The Five Village Society

Ref: Y/18/20/PL - Residential development (6 Houses) - Land
South of Orchard Business Park, N. End Road, Yapton

drawing
SITE PLAN

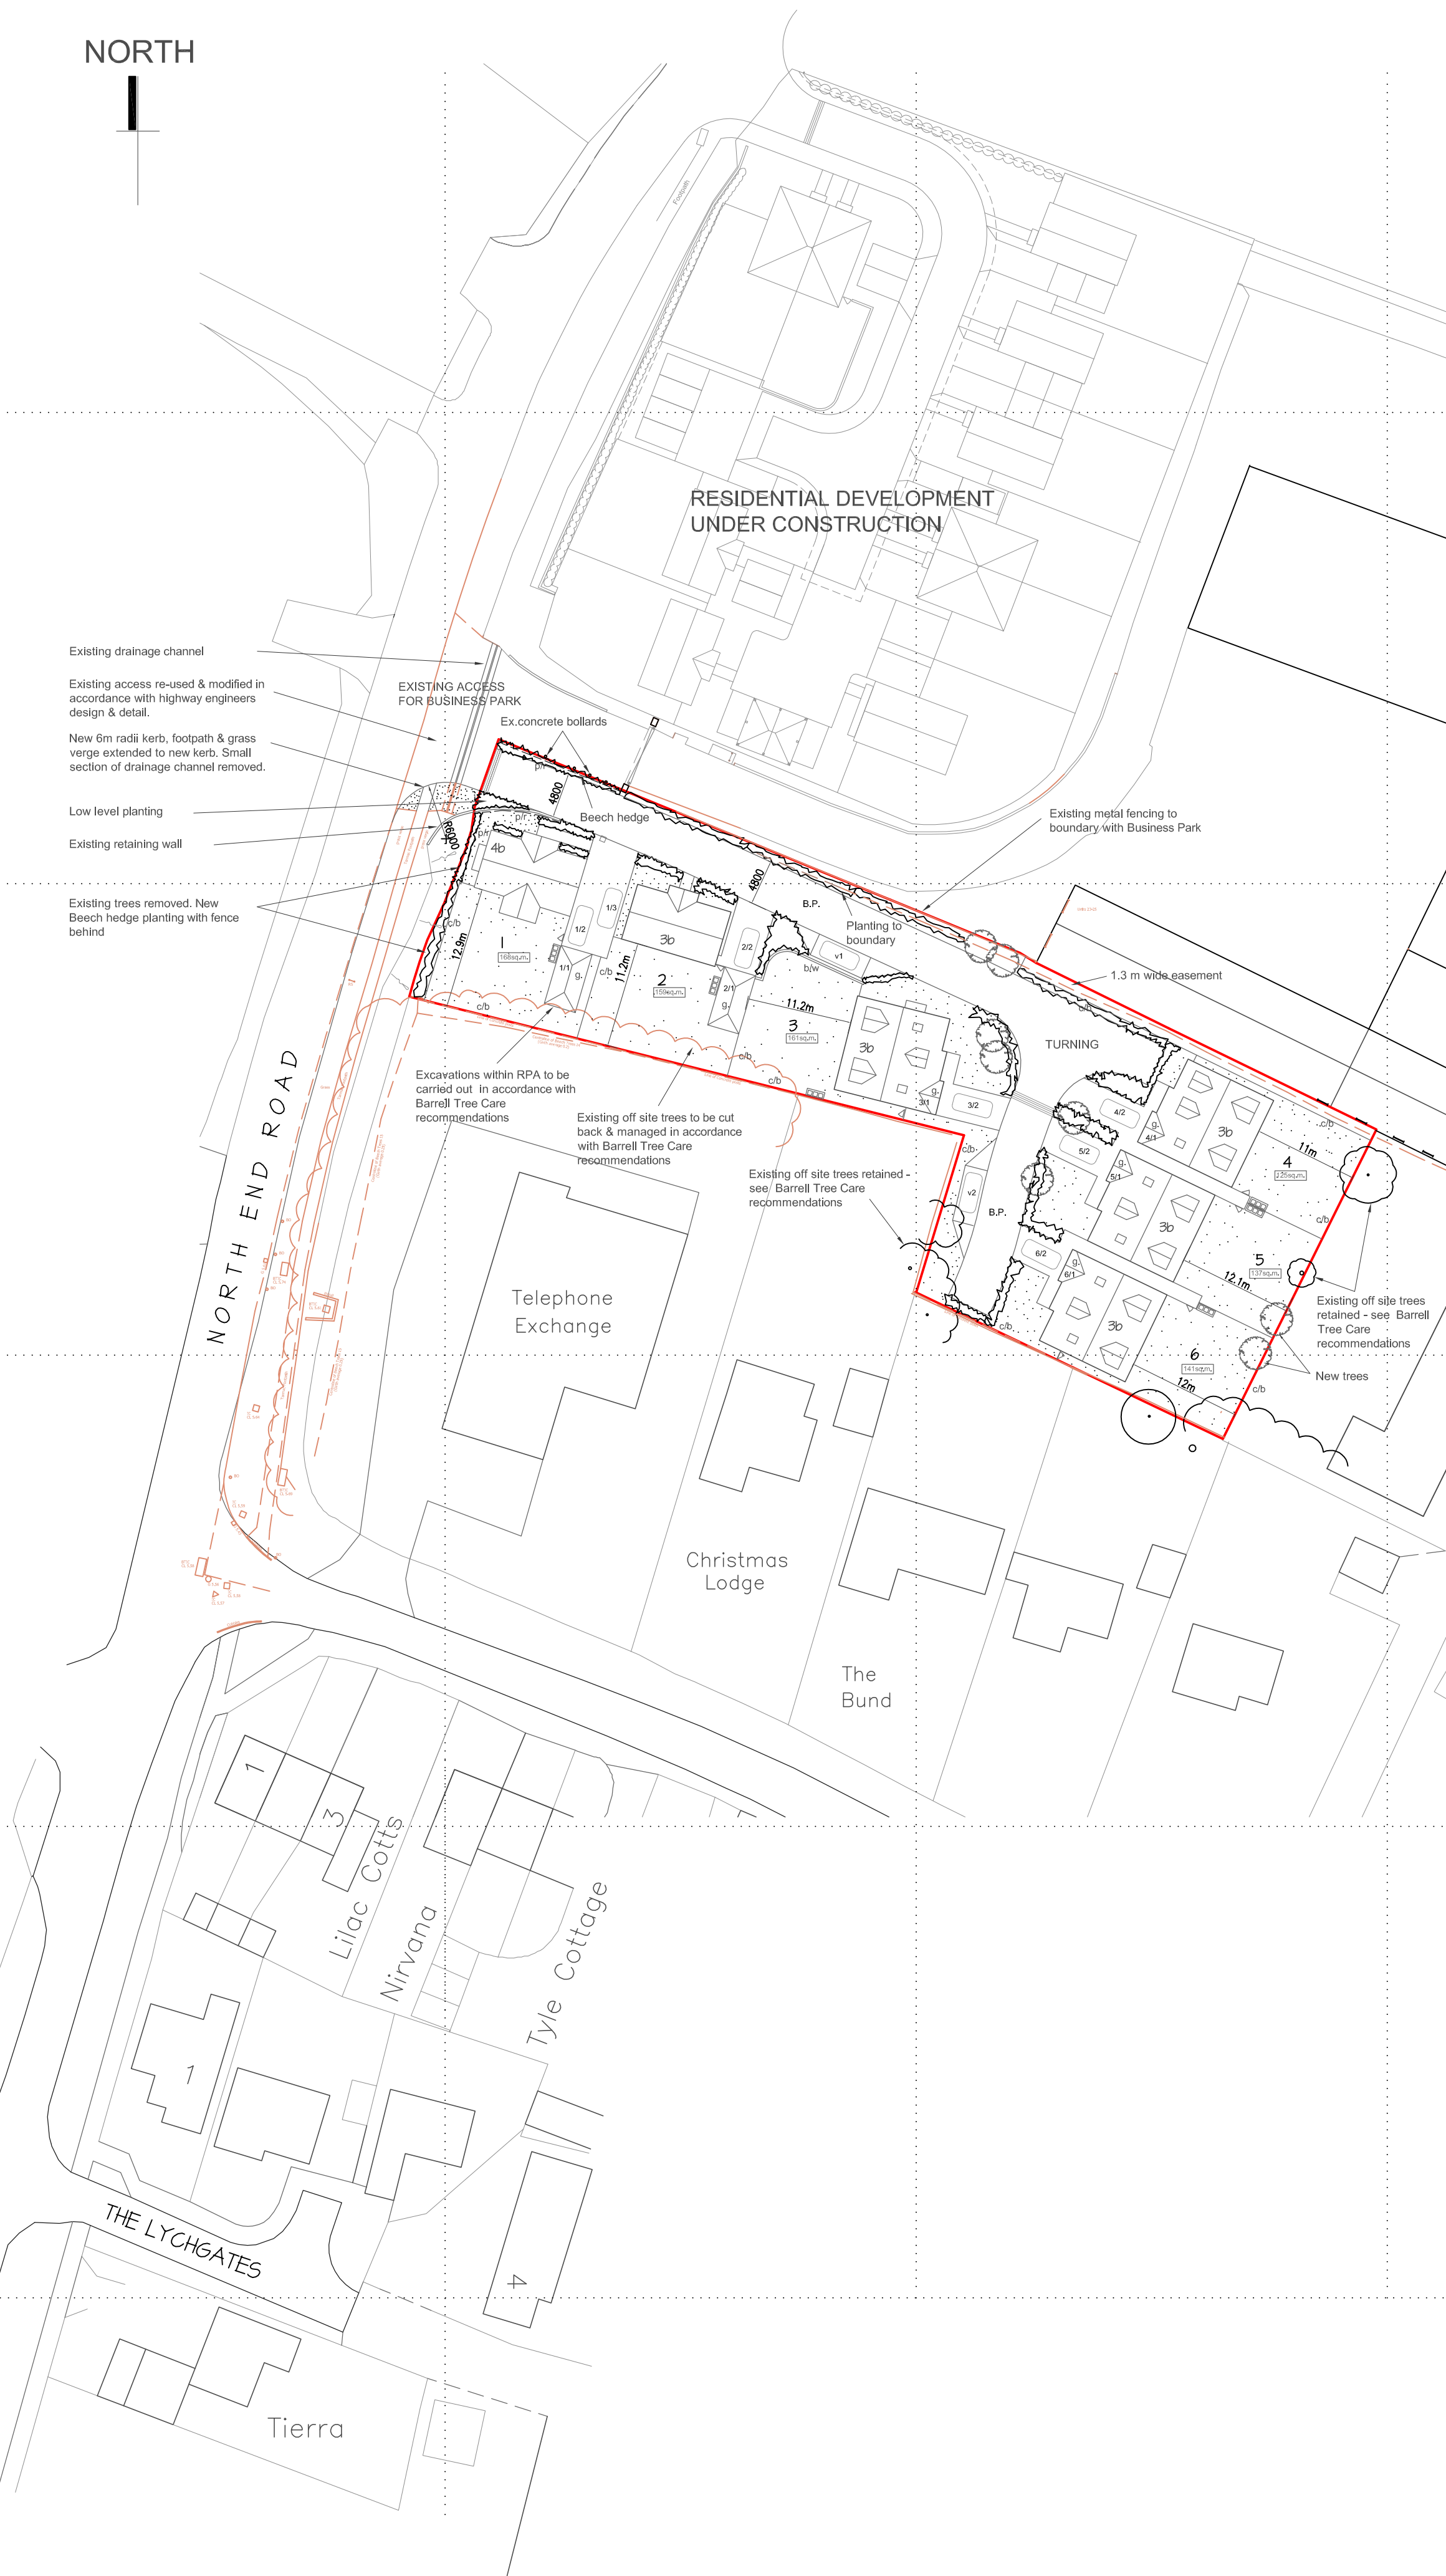
1. The site is not scheduled for residential development.
2. Overdevelopment of a small infill site.
3. Design and layout of the site does not reflect the quality, individuality and spacious layout of adjacent properties.
4. Barrell Tree Care : details of the landscape/tree survey are inaccurate, especially relating to the site boundaries.
5. The roots of trees on boundaries will be affected by building works. The lilac and bottle-brush trees are not identified.
6. The high 2m+ leylandii hedge on the south side (Christmas Lodge boundary), which ensures positive privacy, is not recorded. What will happen to it?
7. SGN 7 "Cyprus" : location is wrong.
8. Plots 4 & 5 : the shared access to the rear gardens is noted. Who is responsible for this pathway?
9. Responsibility for the maintenance of the site fencing after completion of the building work needs to be clarified.
